MARINE RESTORATION & CONSTRUCTION LLC

Re: SHL23-016 SUB1 Review Letter; 9150 Fortuna Dr (Site), Mercer Island, WA 98040

We received *SHL23-016-SUB1-PLANS-013123_review.pdf* dated February 2, 2023. We have addressed the comments in the review plan set and published the responses.

We received *SHL23-016 SUB1 Review Letter.pdf* dated February 2, 2023. We have addressed the comments in the section below and have attached supporting documentation.

**PROPOSED FRAMING PLAN**

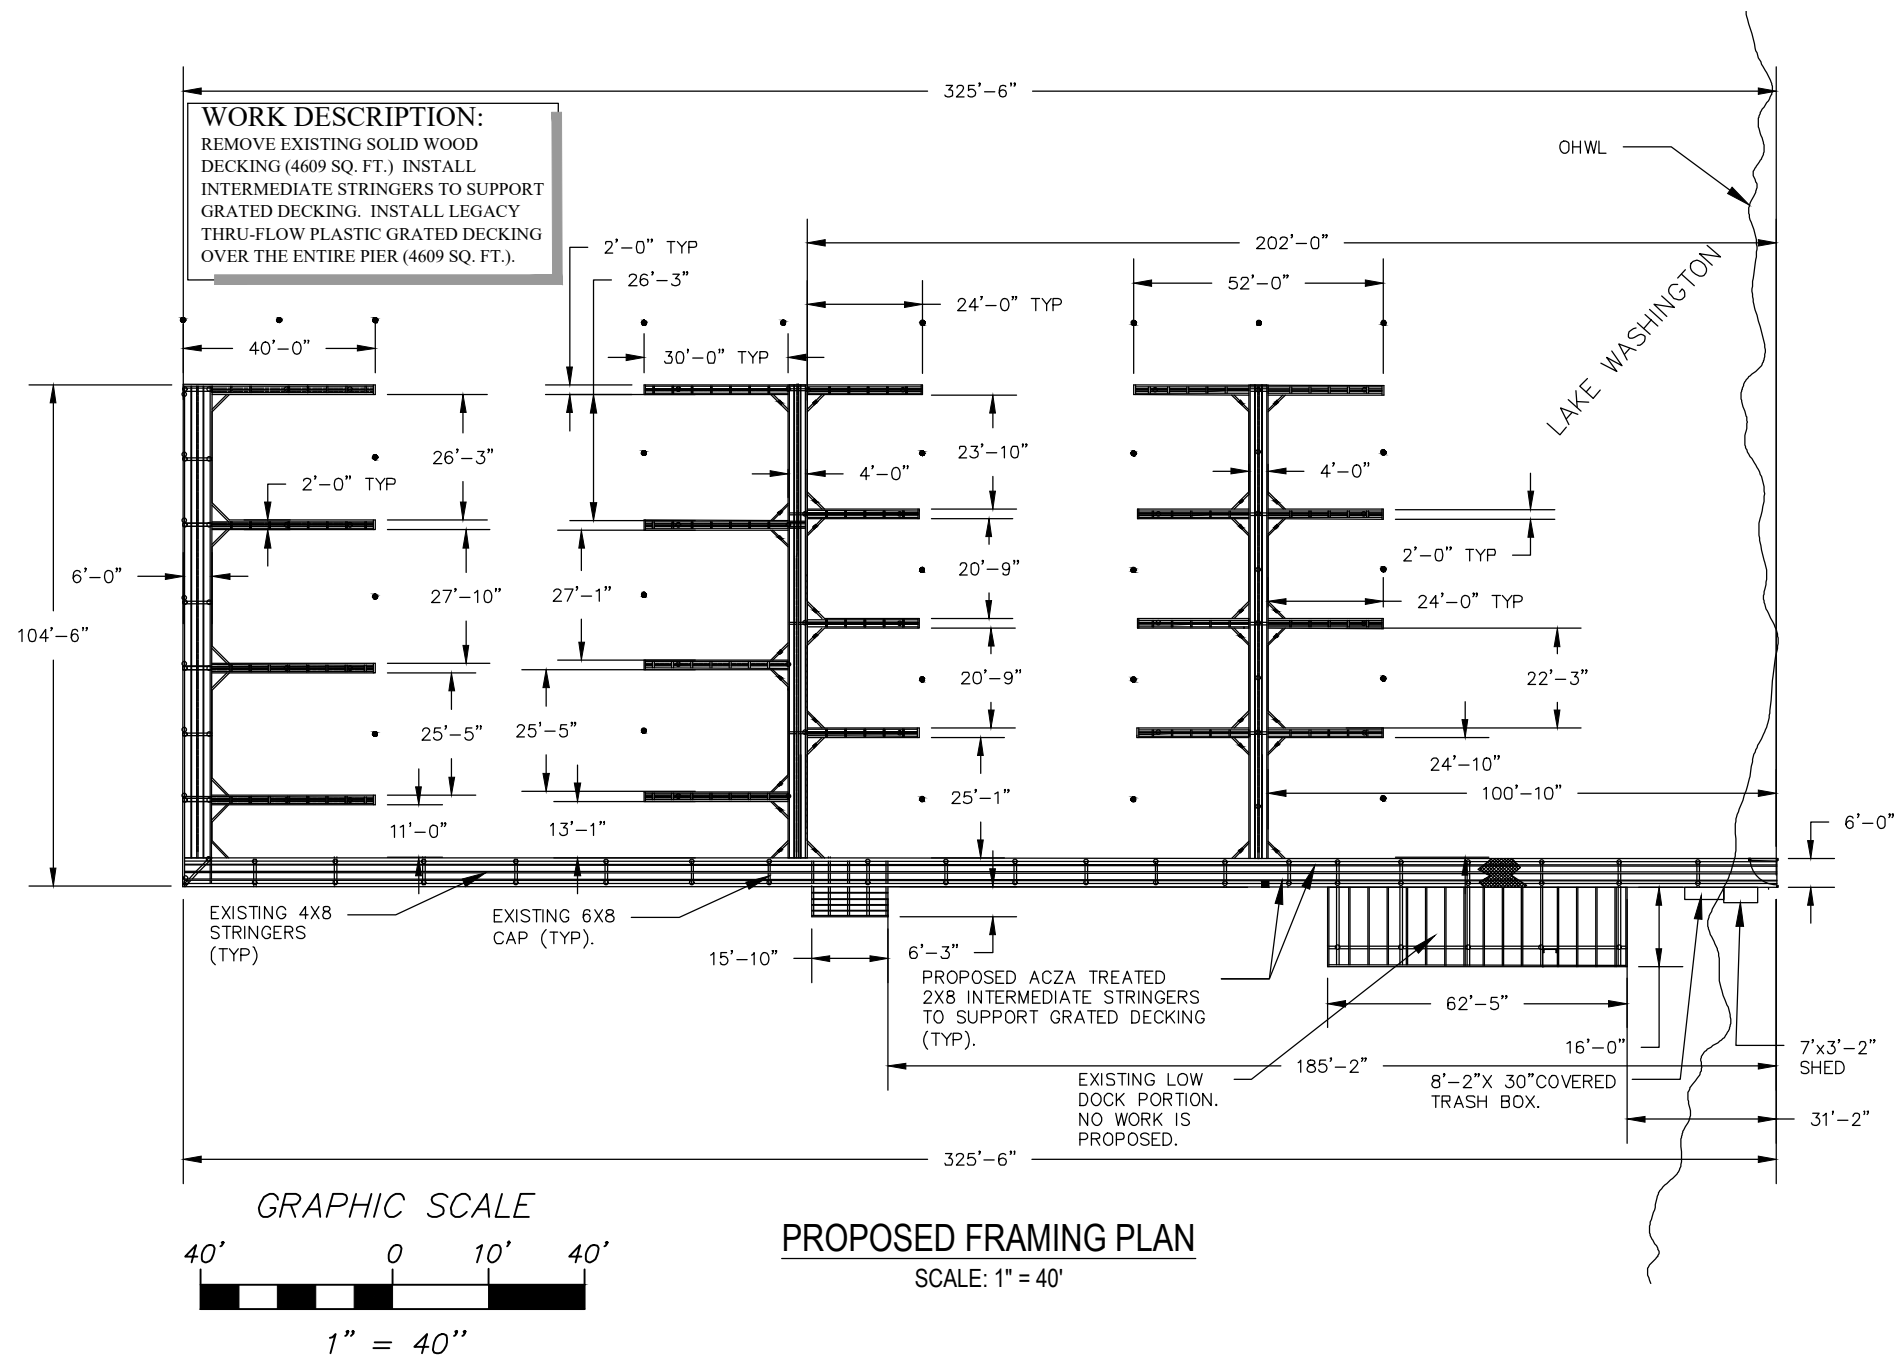
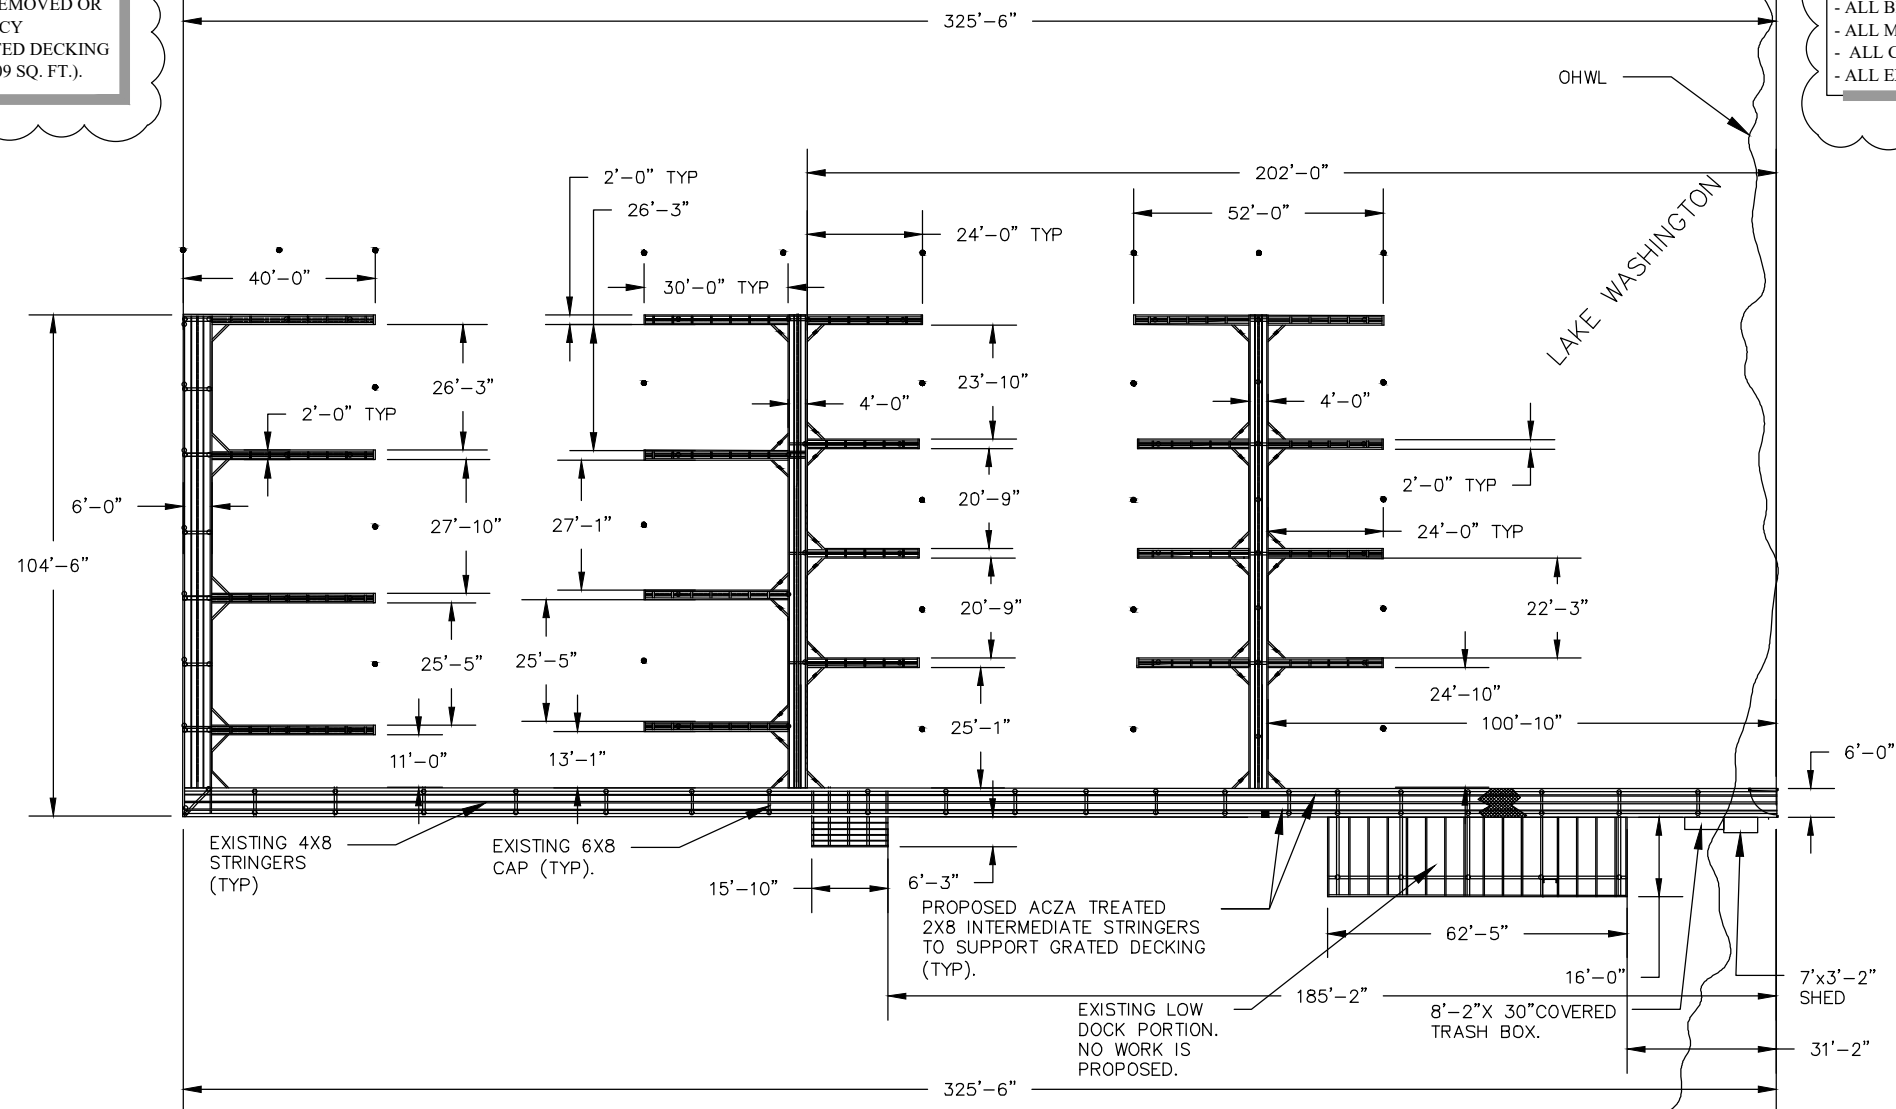
3. Confirm that the existing stringers will not be removed or replaced. Add this note to the proposed framing plan.

The existing stringers will not be removed or replaced. No work is proposed on the existing stringers. The proposed framing plan has been updated to reflect this. Please see corrected plan set dated 2-9-23.
